Planning Department
Arun District Council
1 Maltravers Road
Littlehampton
BN17 5LF

Re : Planning Application P/58/19/PL for the erection of 9 dwellings. Deadline for objections 15th August.

I would like to object to the above planning application for 8, 3 bedroom, 2 storey houses and 1, 2 bedroom, 2 storey chalet bungalow for the reasons stated below.

2017-3763-002

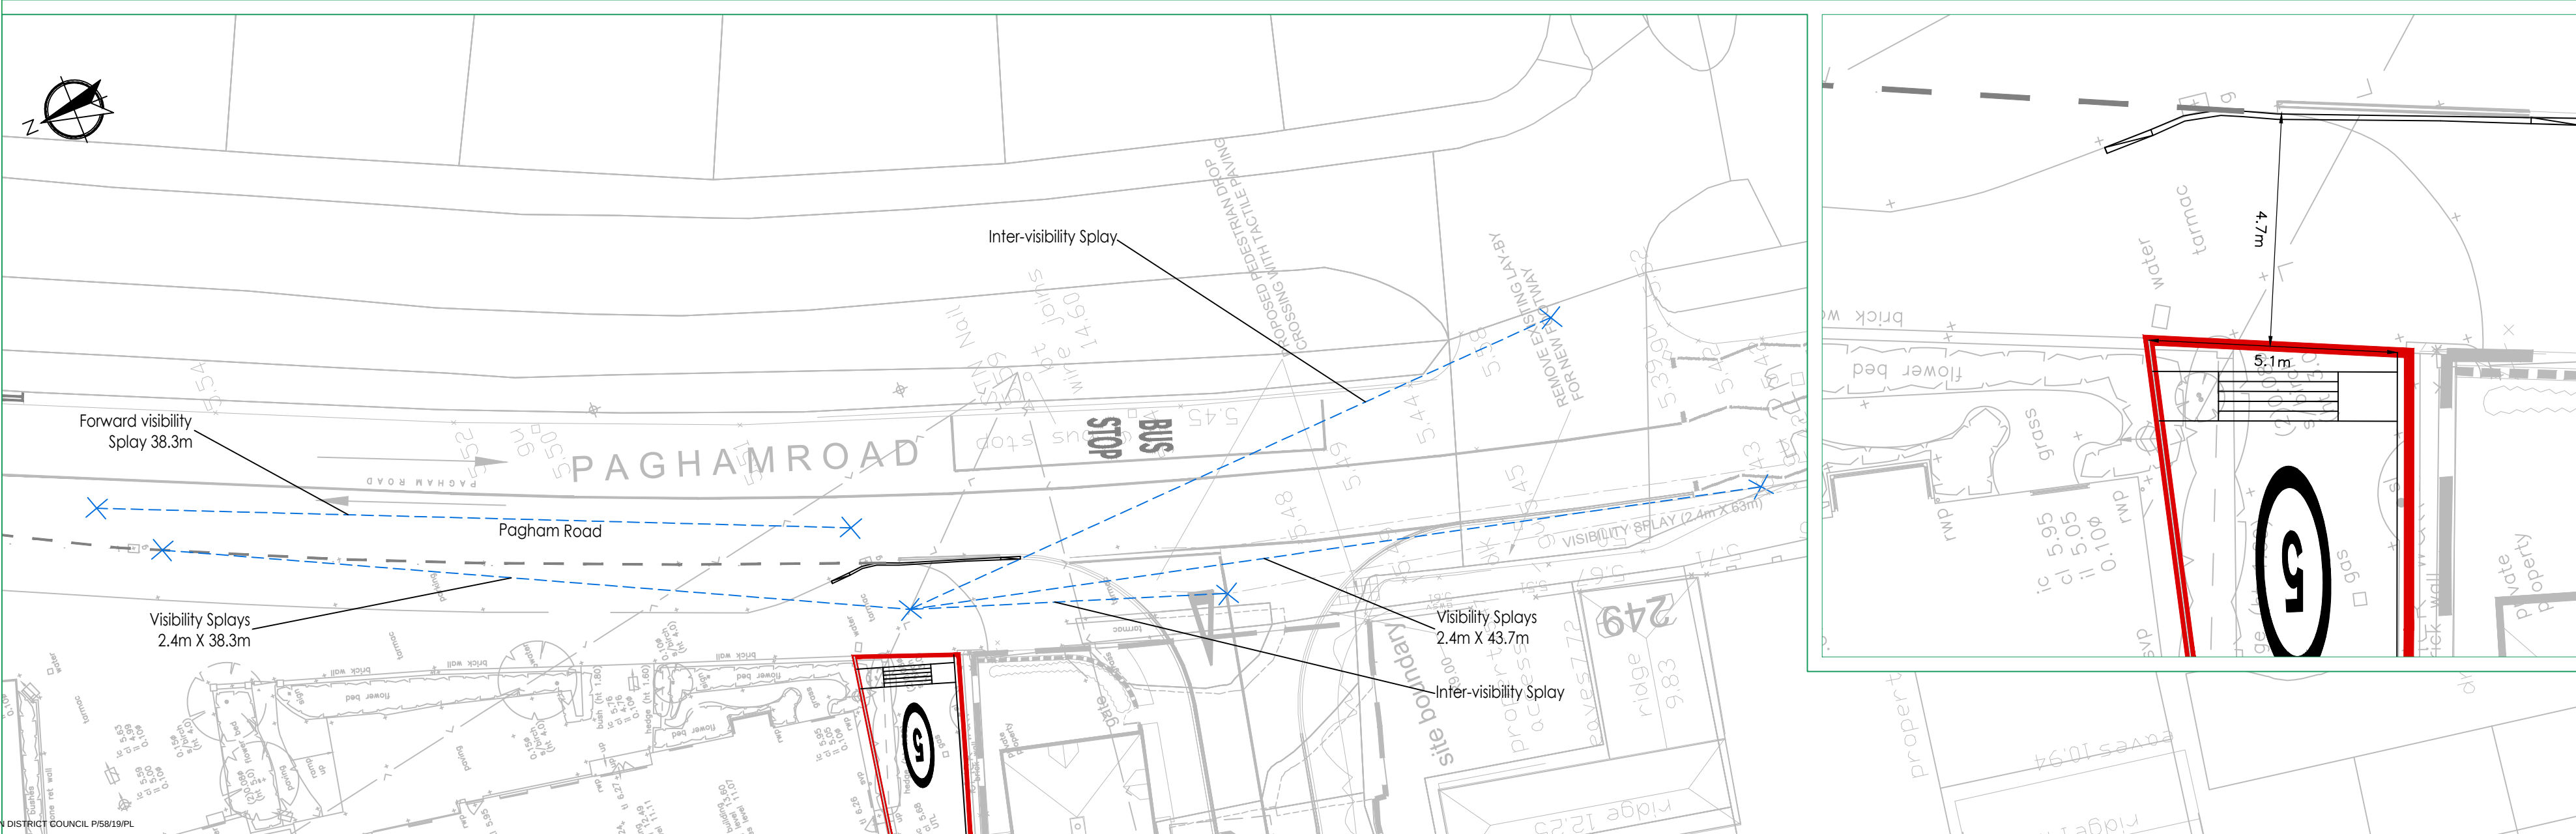
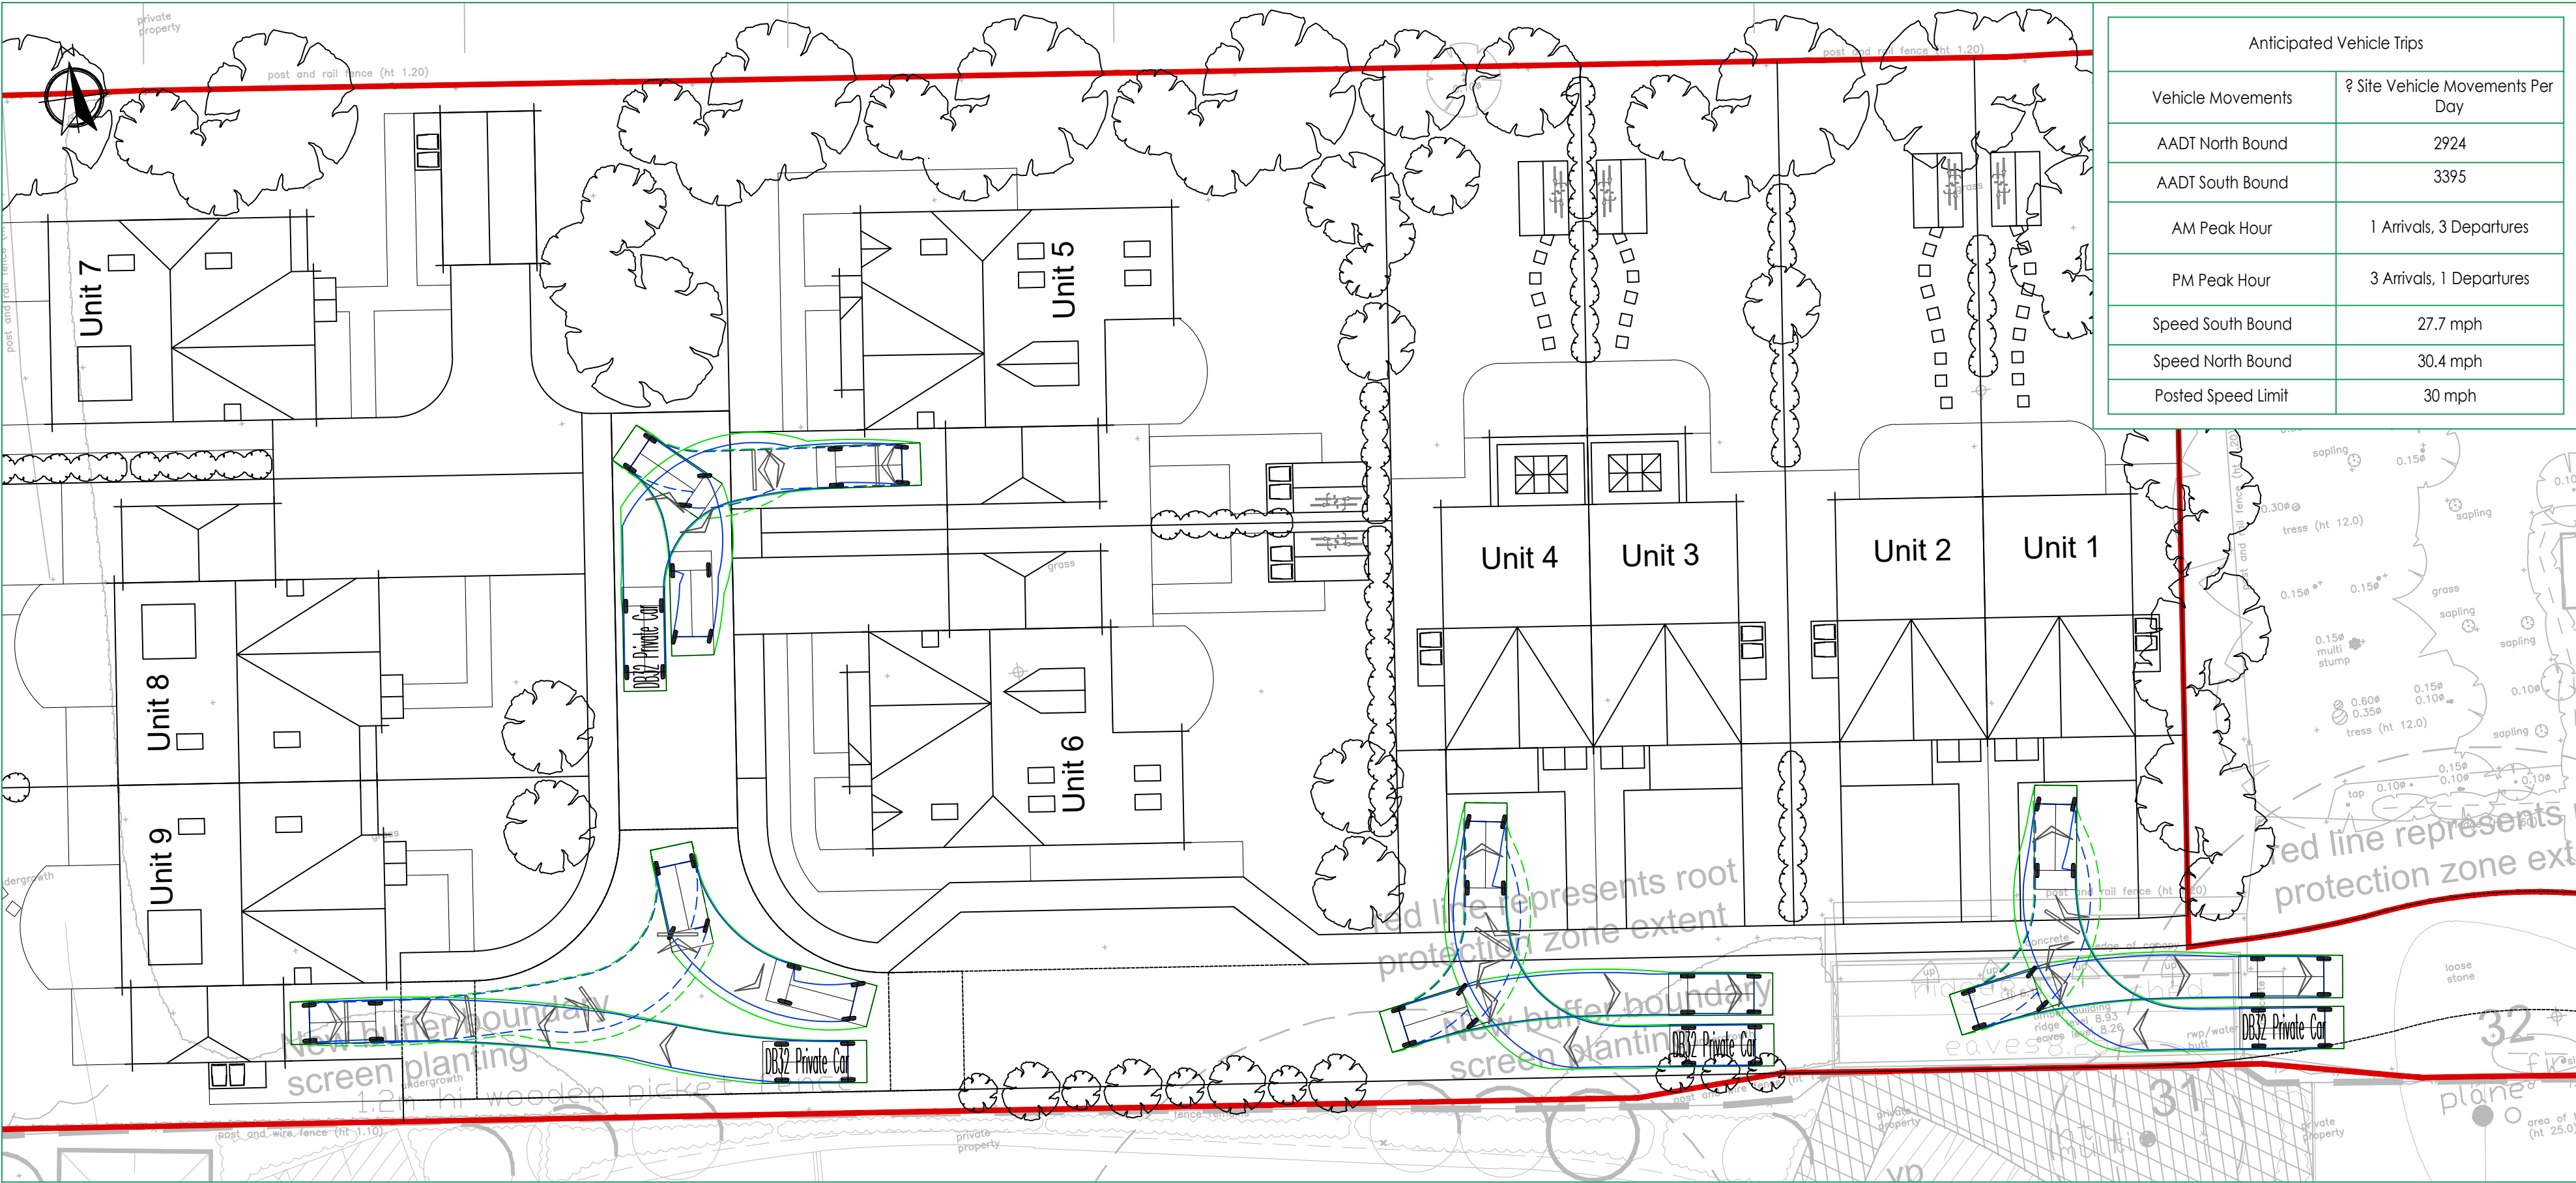
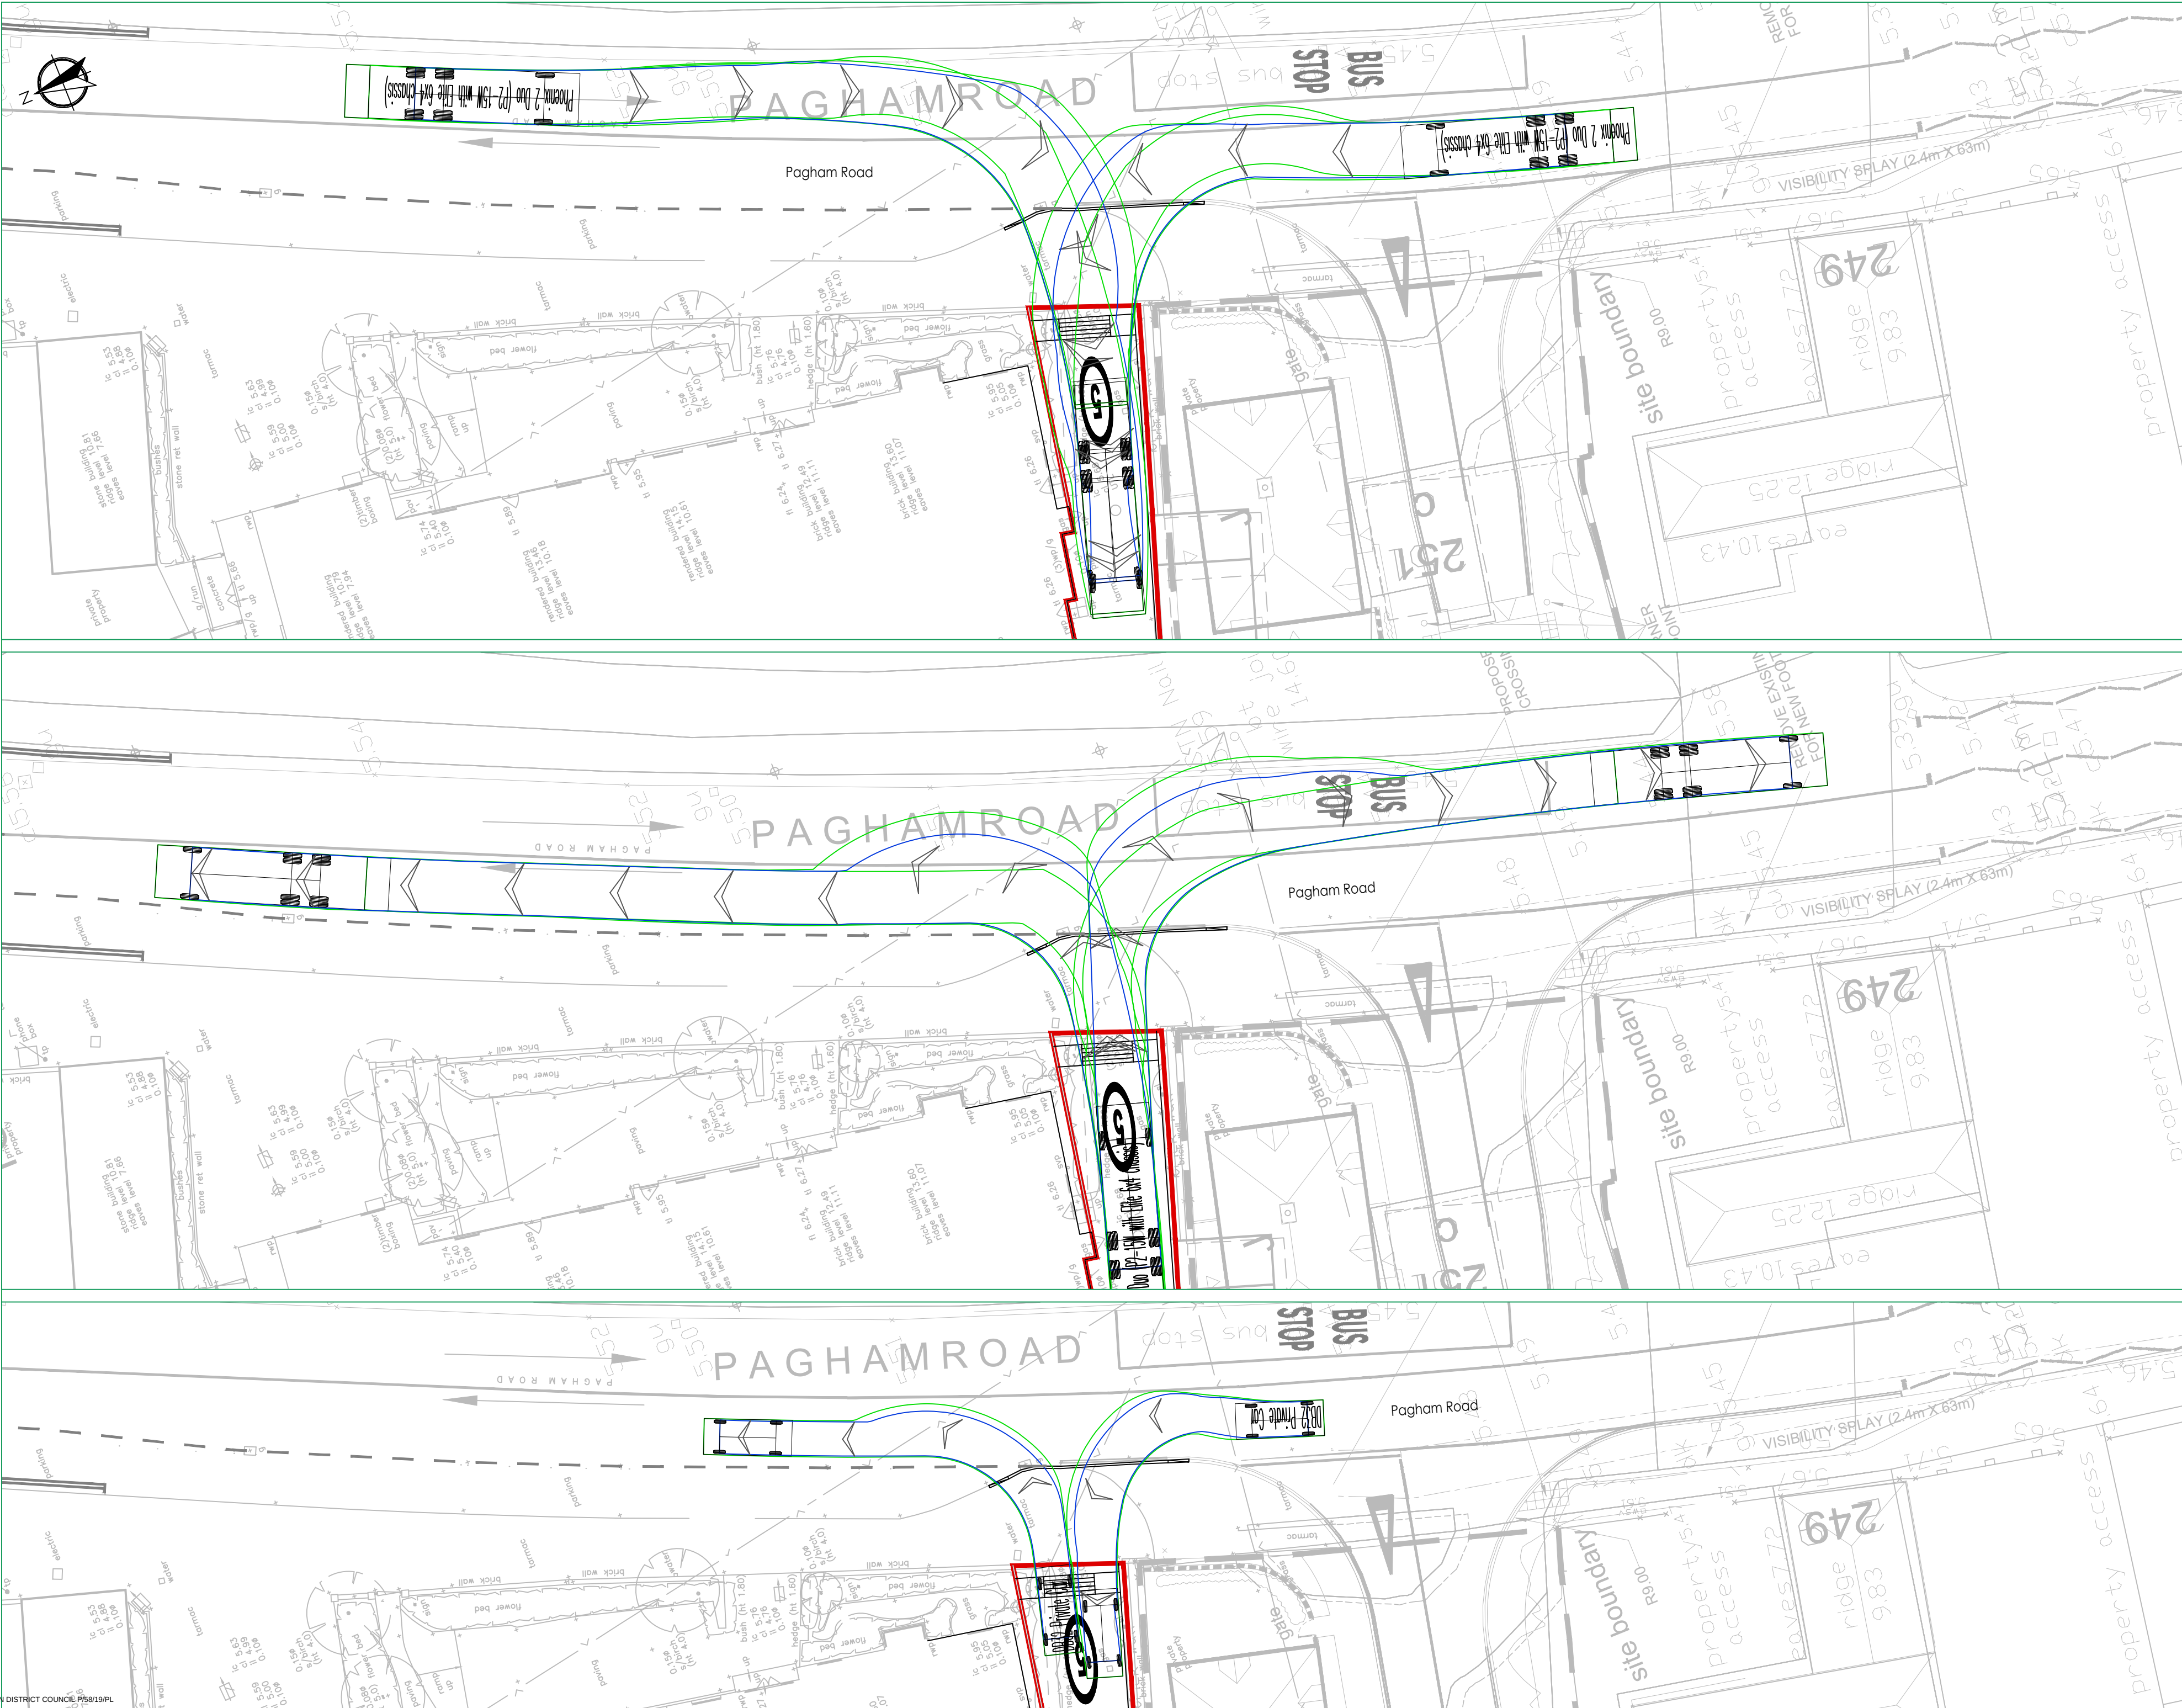
The limited widening of the access road and the significantly increase in vehicle movements entering and exiting the site onto the Pagham Road will have an adverse effect on highway safety and convenience of road users. The planning application states the access lane entrance will be widened to 5.3m after re-alignment and a traffic light system will be introduced. There may still be occasion when two cars will be accessing the lane at the same time, therefore one will still have to wait on the pavement area. An example of vehicle widths: A BMW X5 is 2.4m wide, average car 2m, refuse/commercial vehicle 3m wide. It is also proposed that pedestrians will be using a shared surface in the access lane.

Manual for Streets item 6.3.22 states "that a minimum unobstructed width for pedestrians should generally be 2m". Therefore, the width of 5.3m achieved could cause a conflict to arise between traffic and pedestrians.

The development access is opposite a bus stop. Cars exiting and entering the access lane will have to overrun the footway to enter the highway traffic. The existing pavement splay creates a small parking area immediately to the north which will restrict their view of traffic entering the village from that direction. Parked cars on the highway opposite the Hotel encourages traffic to use the middle of the road therefore emerging vehicles from the development will be waiting on the footway/splay to enter the Pagham Road at the narrowest section of the highway.
